2021 SCOPING RESPONSES

RE: Scoping Opinion for Gortloughra Windfarm.

Scoping Opinion for Gortloughra Windfarm, Kealkill, Bantry, Co. Cork

Figure 14.1 – Site Layout

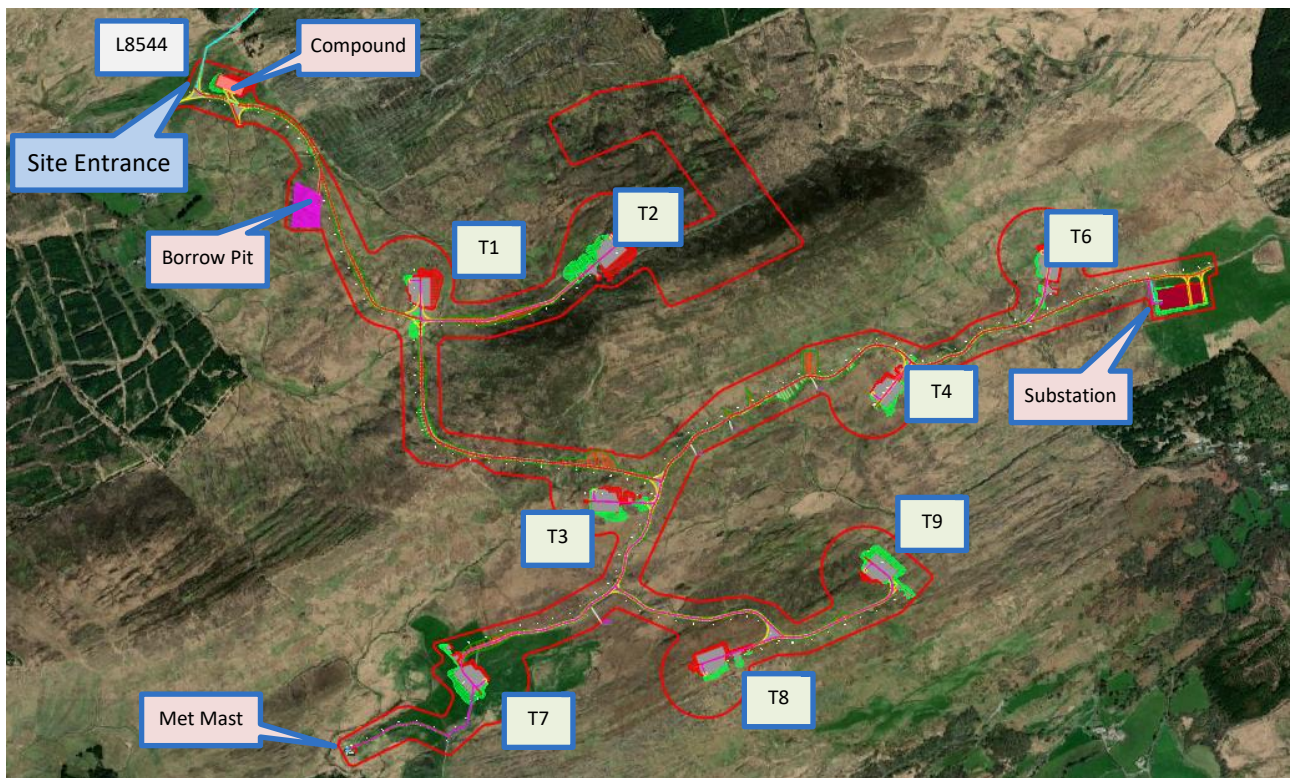
The Area Engineer notes little detail is supplied regarding the turbine delivery route and indicates that the submitted map is very difficult to read, despite extensive knowledge of the area. The report notes a large number of residential properties with a dwelling located 600m from T6 but not shown on figure 14.1.
